Recommendation Report for Planning Permission

REF NO: AB/6/25/PL

LOCATION: Sparks Yard  
18 Tarrant Street  
Arundel  
BN18 9DJ

PROPOSAL: Conversion of existing single residential unit with associated commercial space to form 3 No. residential units together with associated works and rear/side extension. This application affects the setting of listed building, affects the character and appearance of the Arundel Conservation Area, is in CIL Zone 2 and is CIL Liable as new flats.

PROPOSED SOUTH ELEVATION (TARRANT STREET) 1:100

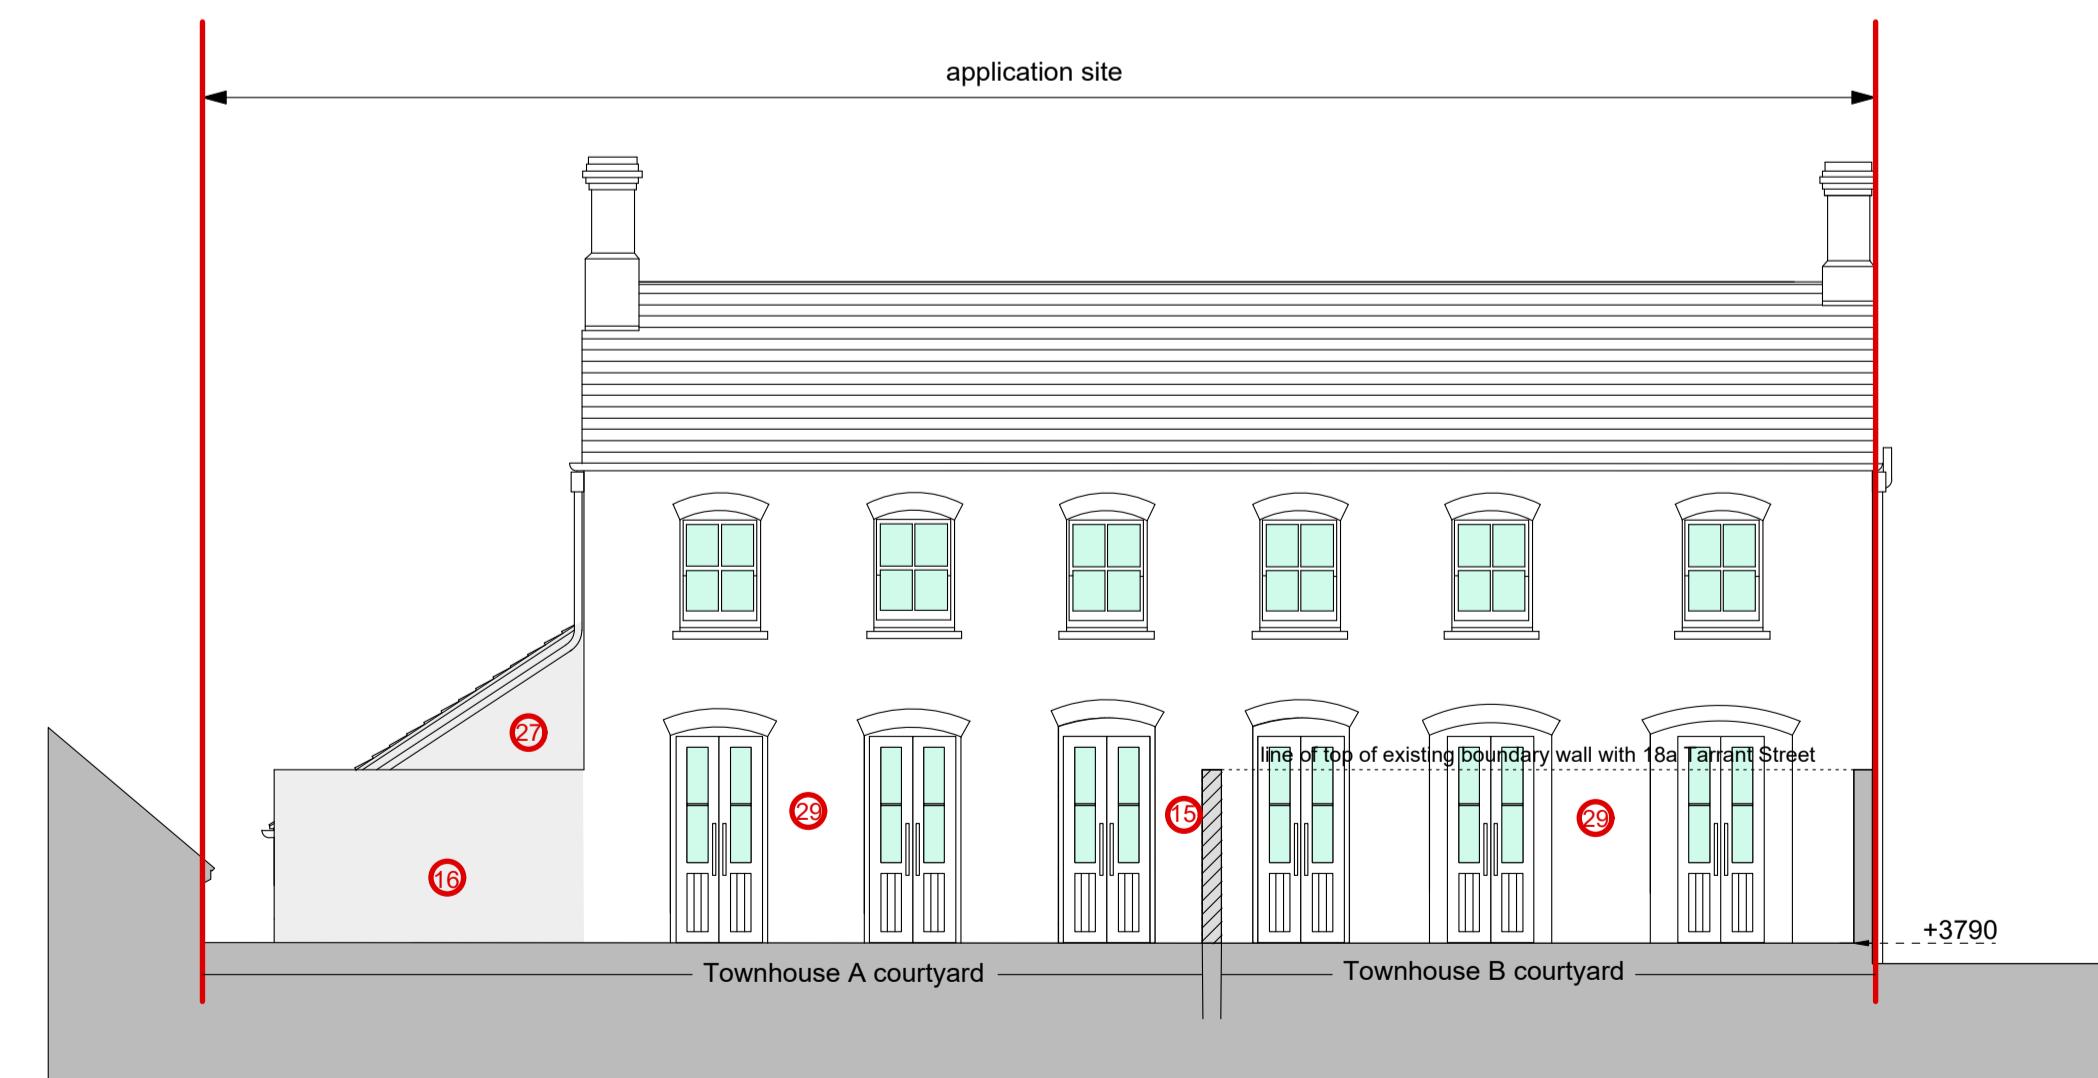
- Concerns the proposal is an overdevelopment of the site.
- Concerns that the use of obscured glazing for bathrooms on the front elevation would be inappropriate and have an adverse effect on the character and appearance of the building.

The front elevation of the building would be altered through the replacement of the timber service doors to the west side with an entrance lobby, black stained diagonal timber boarding and doors, and the

creation of a similar entrance lobby with black stained diagonal timber doors to the east side. These alterations are relatively limited and would have a sympathetic relationship to the form of the existing building. They are acceptably integrated and of acceptable materials.

## PROPOSED EAST ELEVATION (1:100)

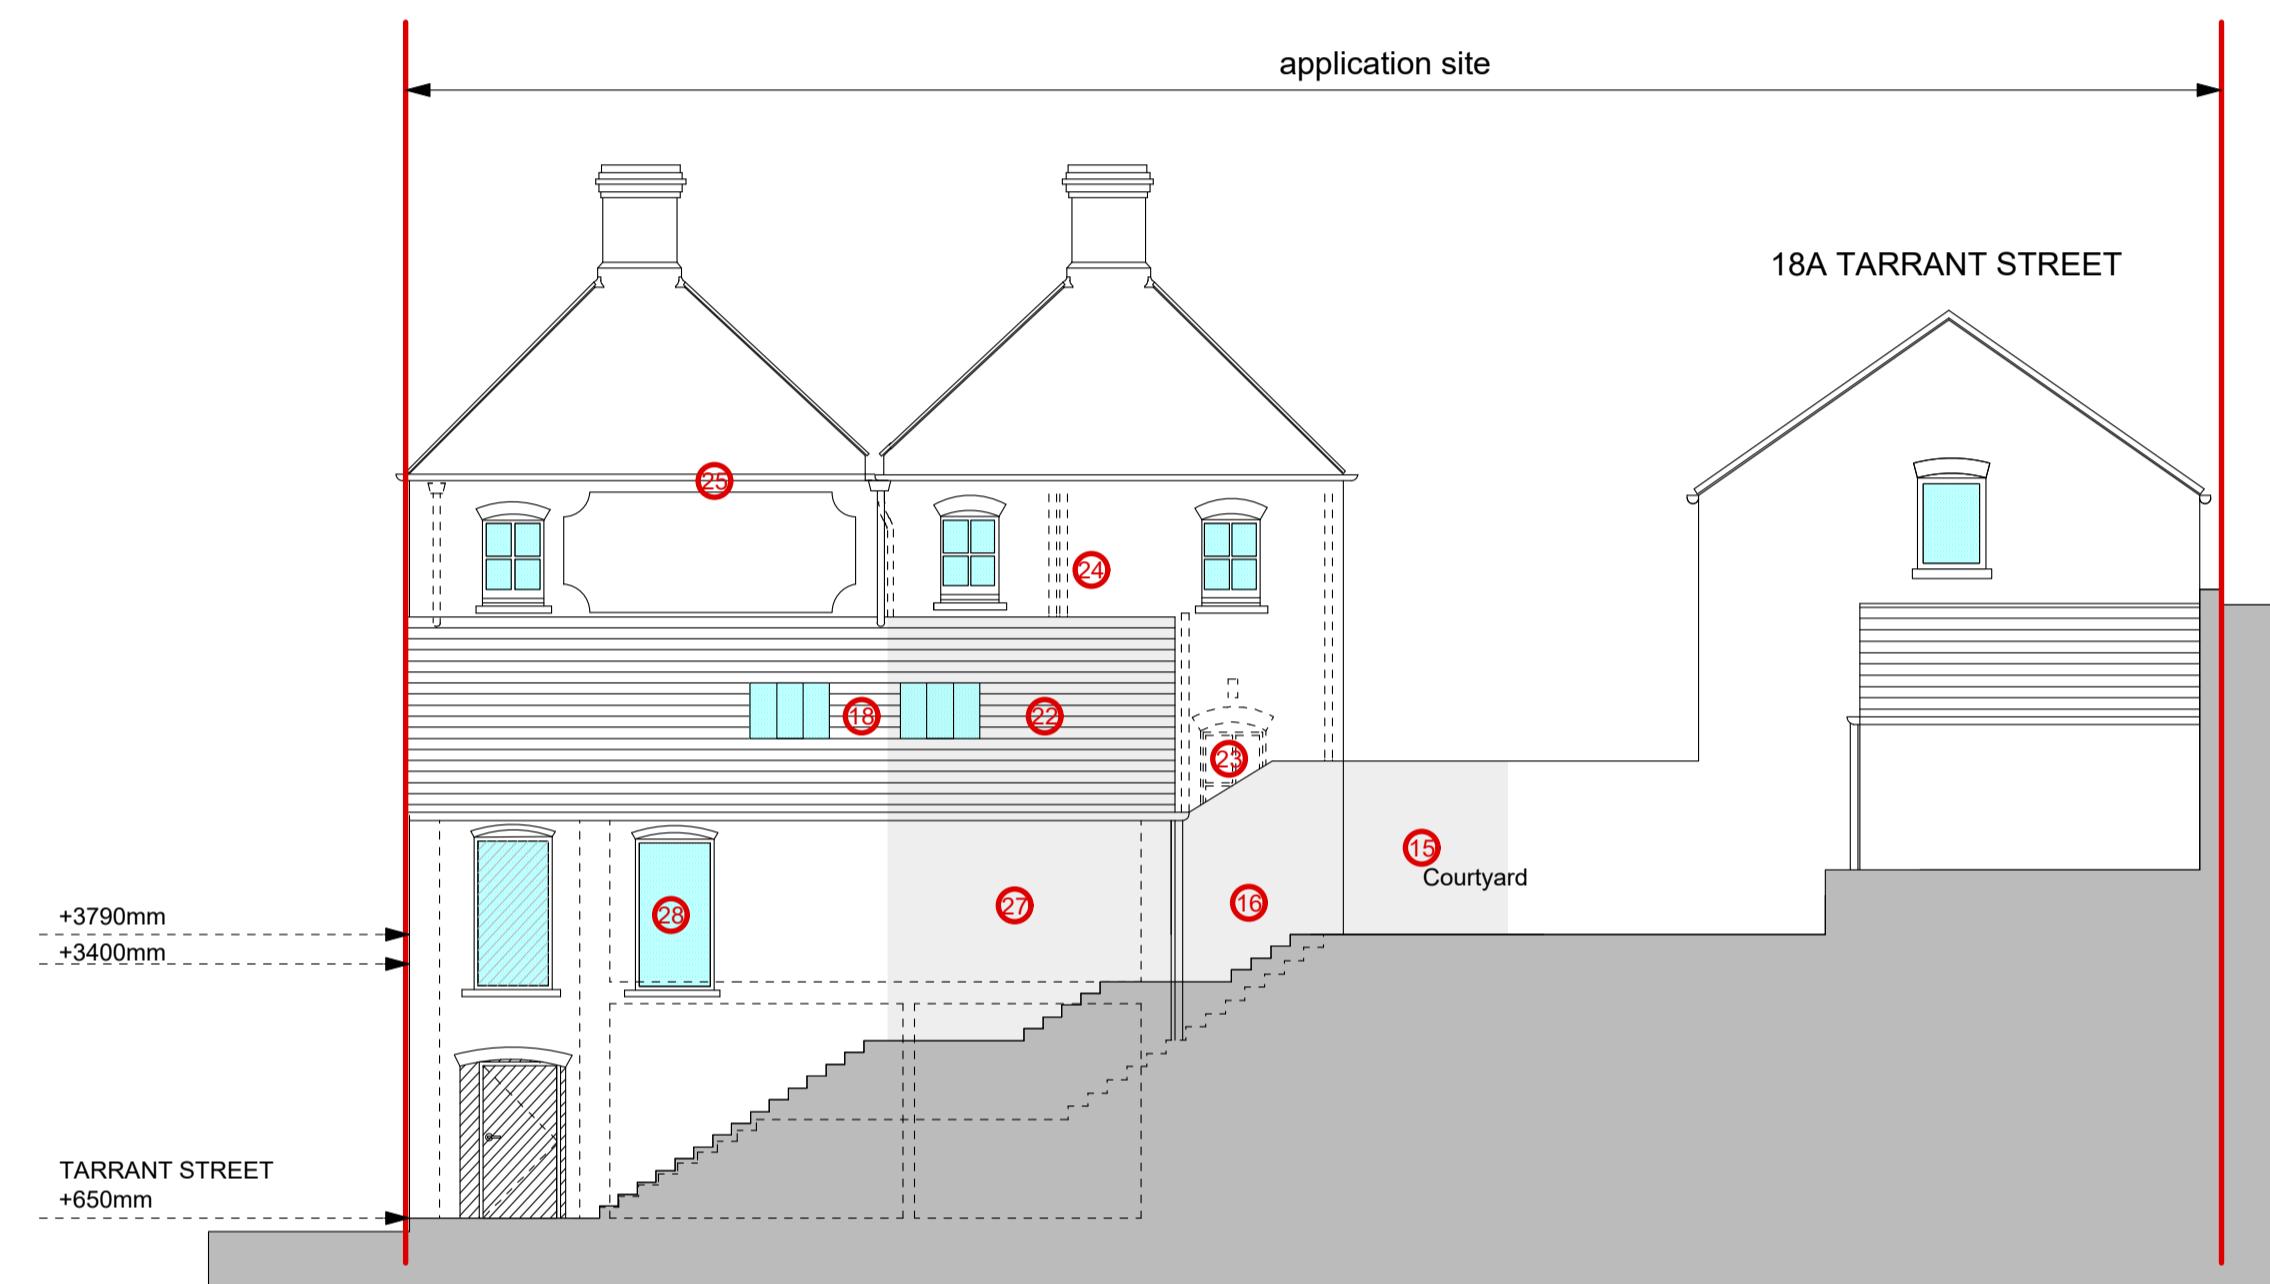
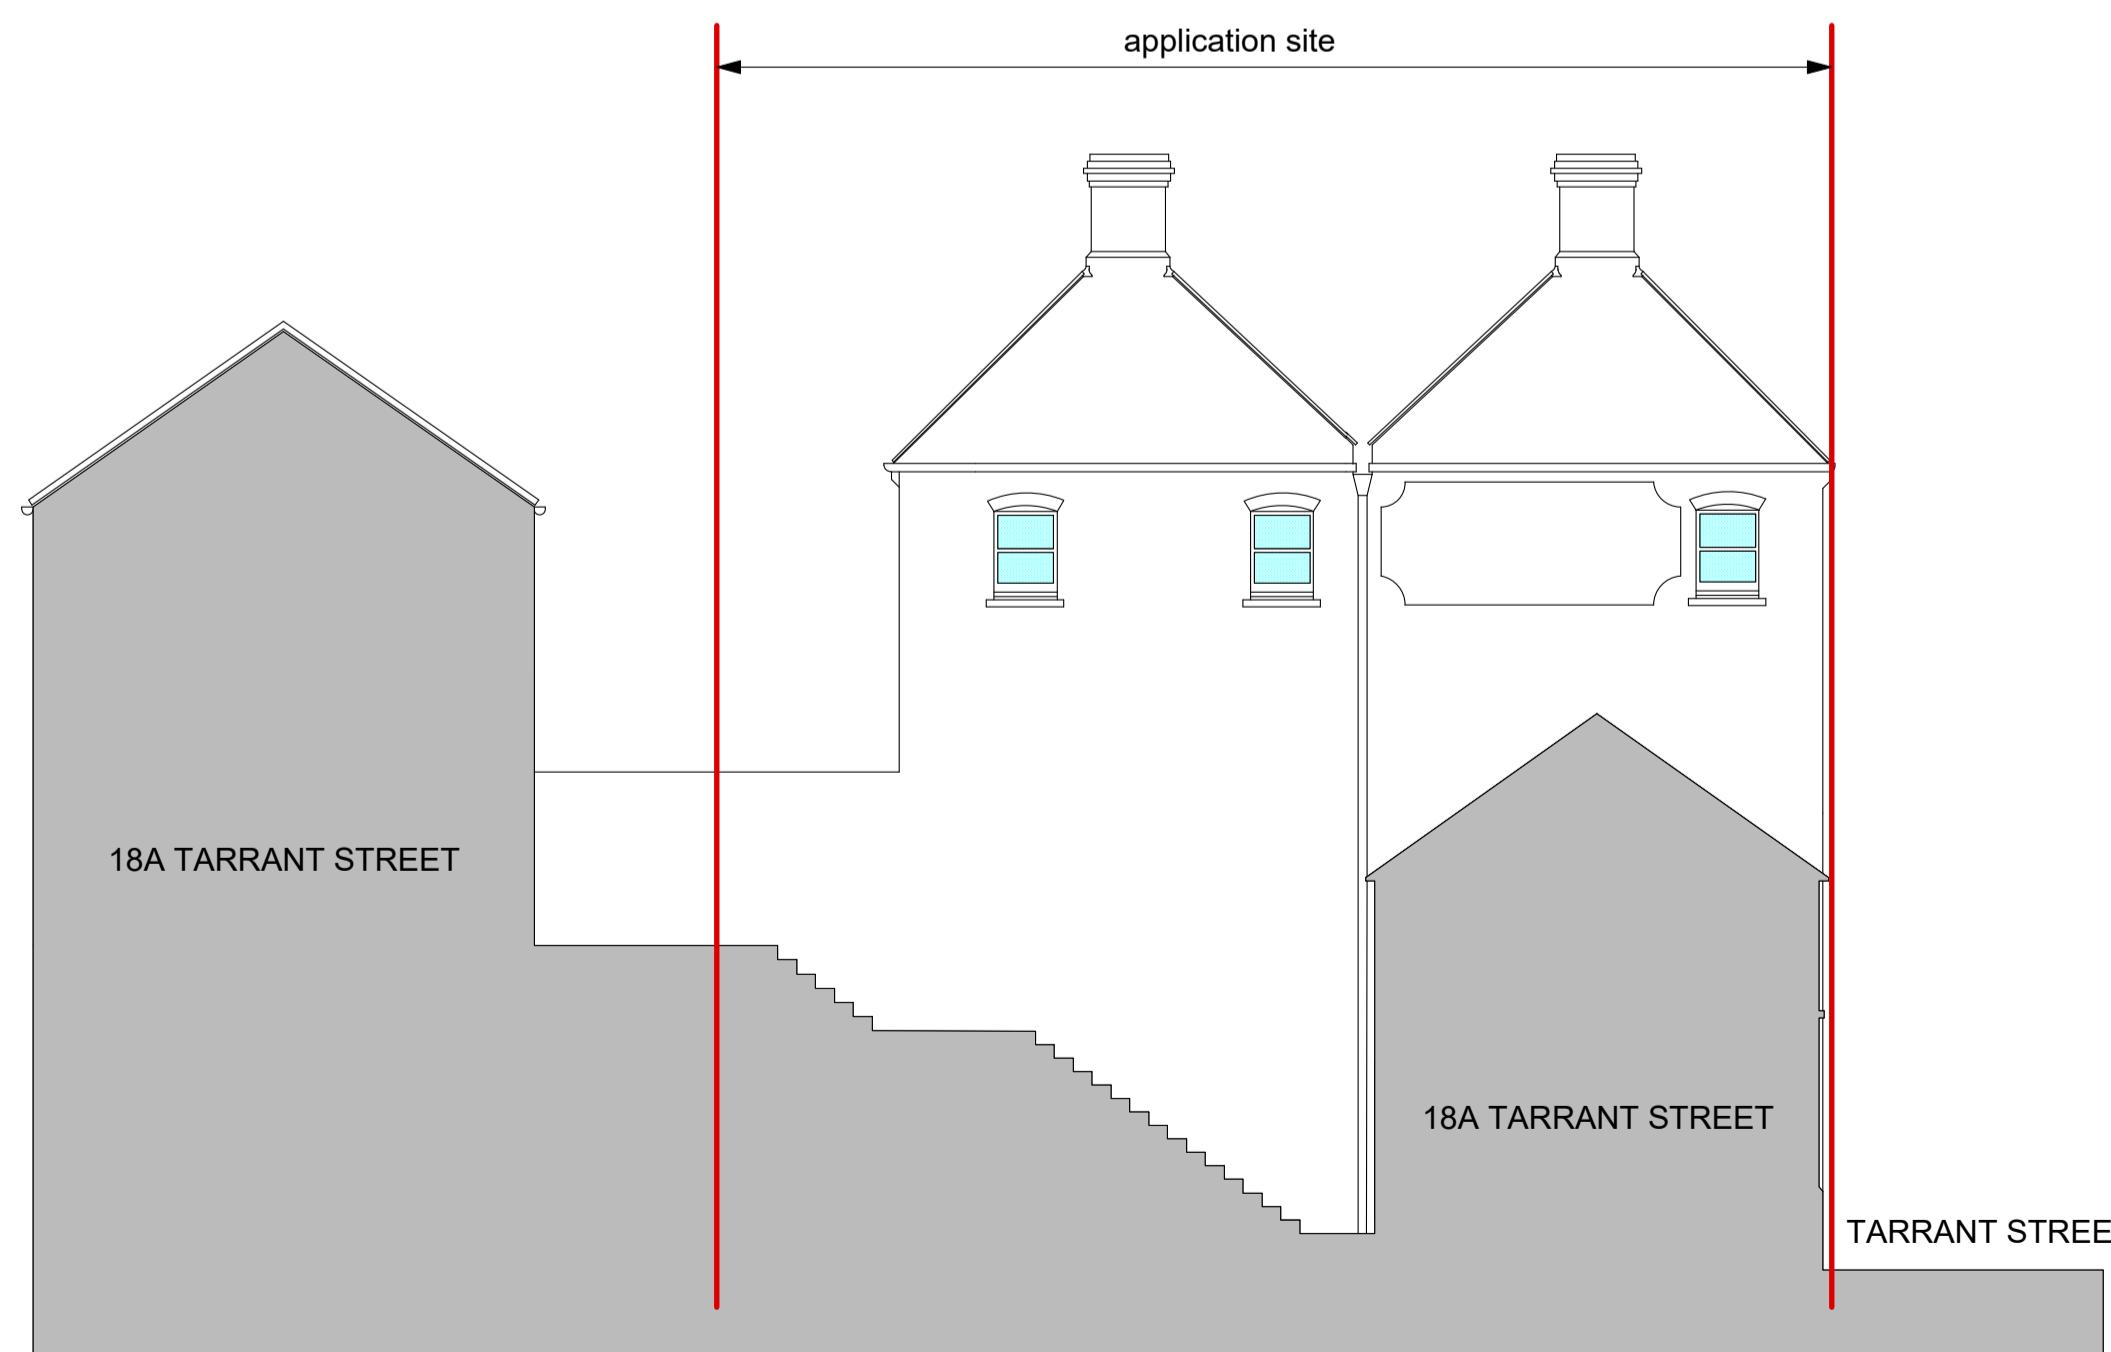
The 2 No. windows at first floor on the eastern elevation of Unit C would have been required to be installed with a design that incorporates 4 panes and integral glazing bars rather than their currently proposed design. Conditions in this respect have been attached to the associated Listed Building Consent application as requested by the Conservation Officer; however, it should be noted that the Listed Building Consent does not purport to grant planning permission for any works that require it.
